East Anglia ONE North and East Anglia TWO Offshore Windfarms

Applicants' Comments Historic England's Deadline 9 Submission

Applicant: East Anglia TWO and East Anglia ONE North Limited
Document Reference: ExA.AS-7.D10.V1
SPR Reference: EA1N_EA2-DWF-ENV-REP-IBR-001057

Date: 6th May 2021
Revision: Version 1
Author: Royal HaskoningDHV

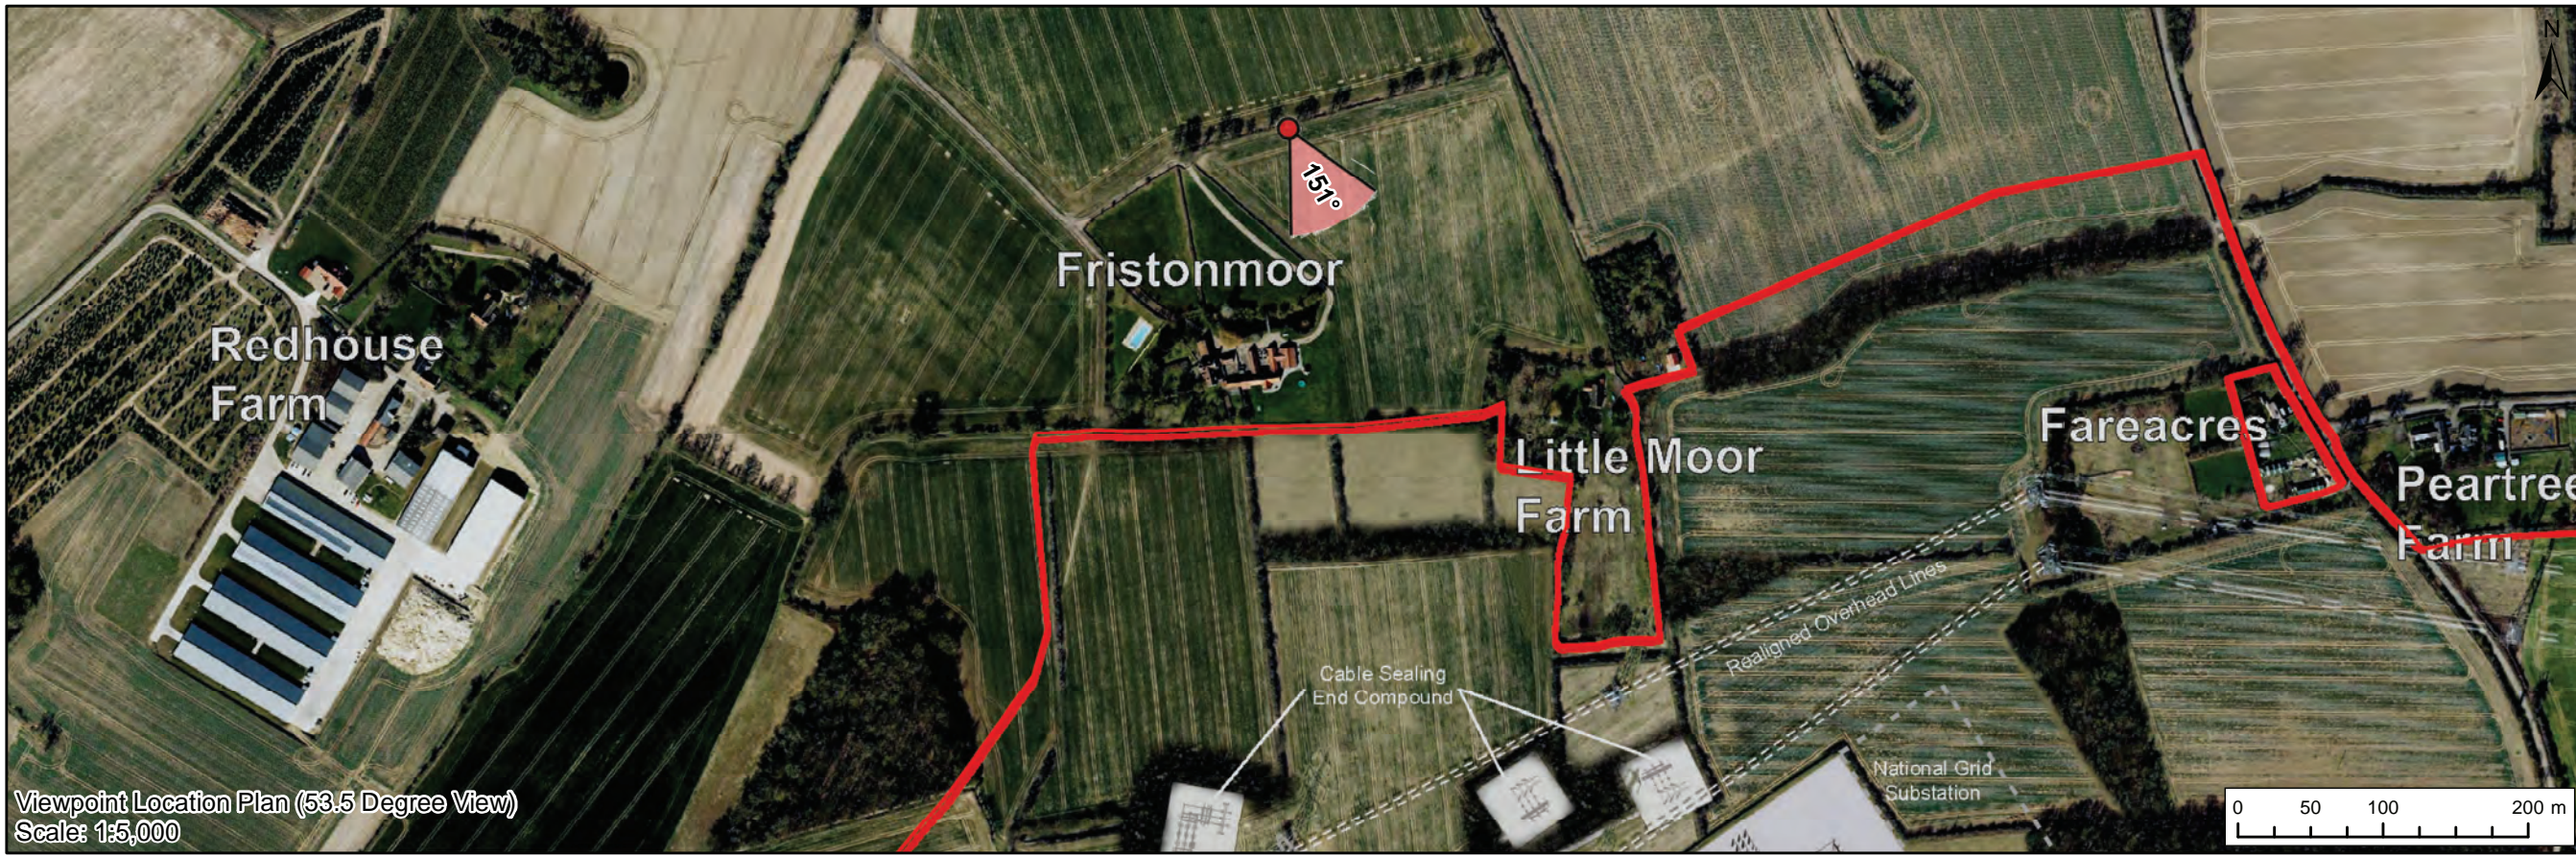
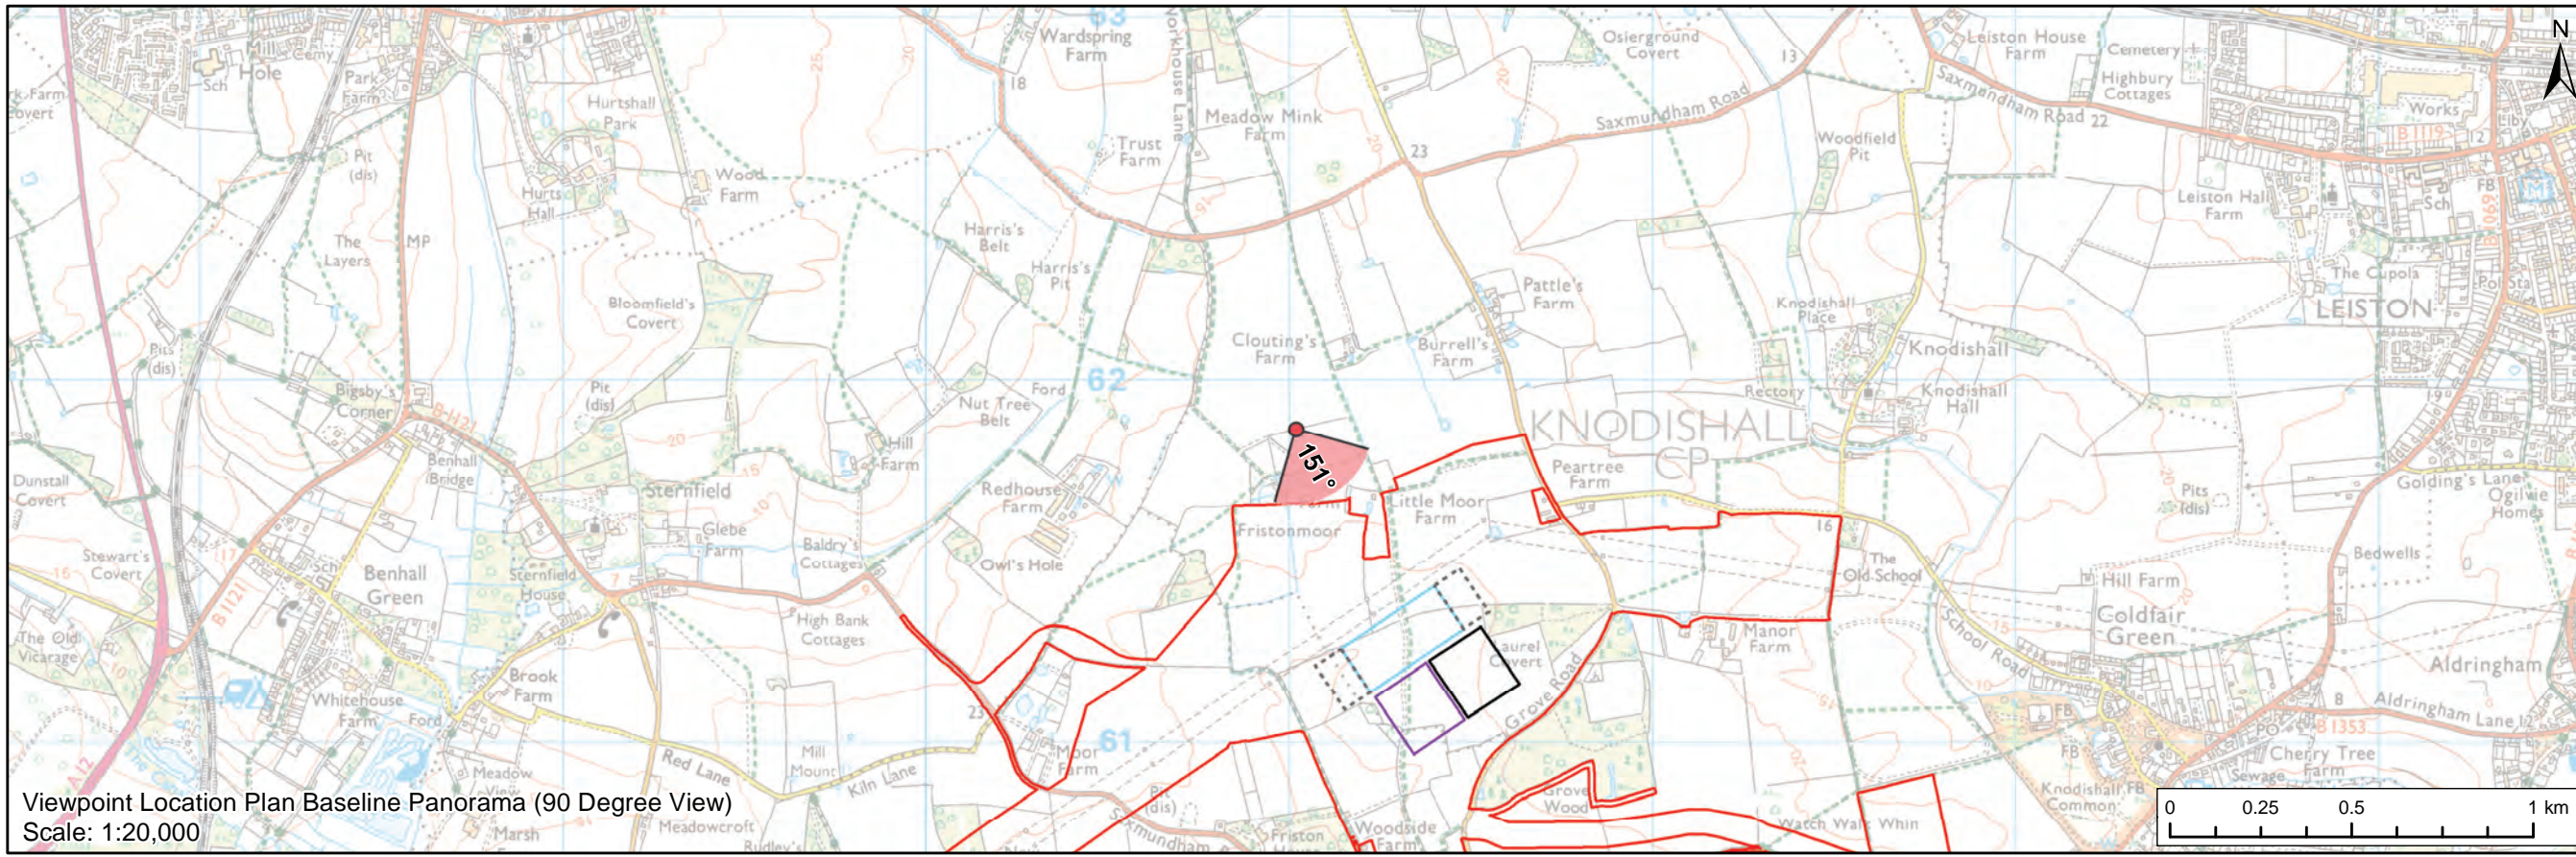
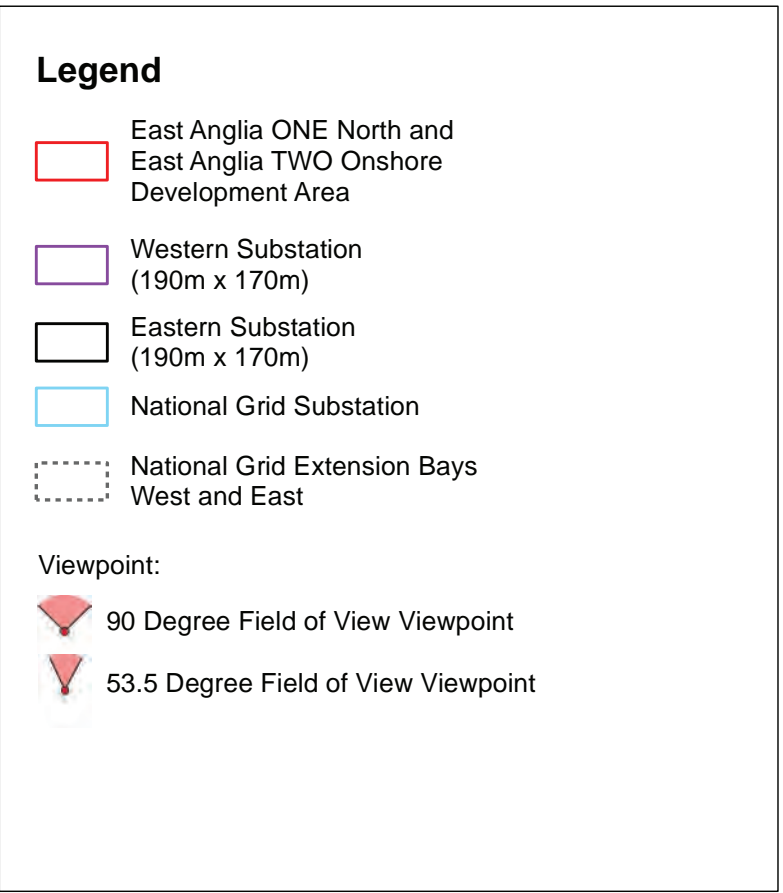
ID	HE's Comment	Applicants' Comments
8	<p>This is demonstrated in part by the Cultural Heritage Viewpoints (e.g. CHVP3 – Appendix 24.7 Figure 8 – Update) which indicates that the extensions to the substation when combined with all the proposed development are likely to further decrease the visibility of the church in the landscape and increase the amount of development in some views, particularly from the north towards Friston and from the north west around Friston Moor.</p>	<p>The Applicants consider that the point being made by HE is not supported by the photomontages that have been provided. Instead the photomontages illustrate how the National Grid substation extensions would be experienced within the visible extent of the existing proposals.</p>
9	<p>The impact upon the historic environment would be potentially more marked from the western extension, which extends in wider arc across open countryside. With the effects of the eastern extension being partially masked by existing landforms of Laurel Covert and from being behind SPRs eastern sub-station.</p>	<p>Agreed.</p>
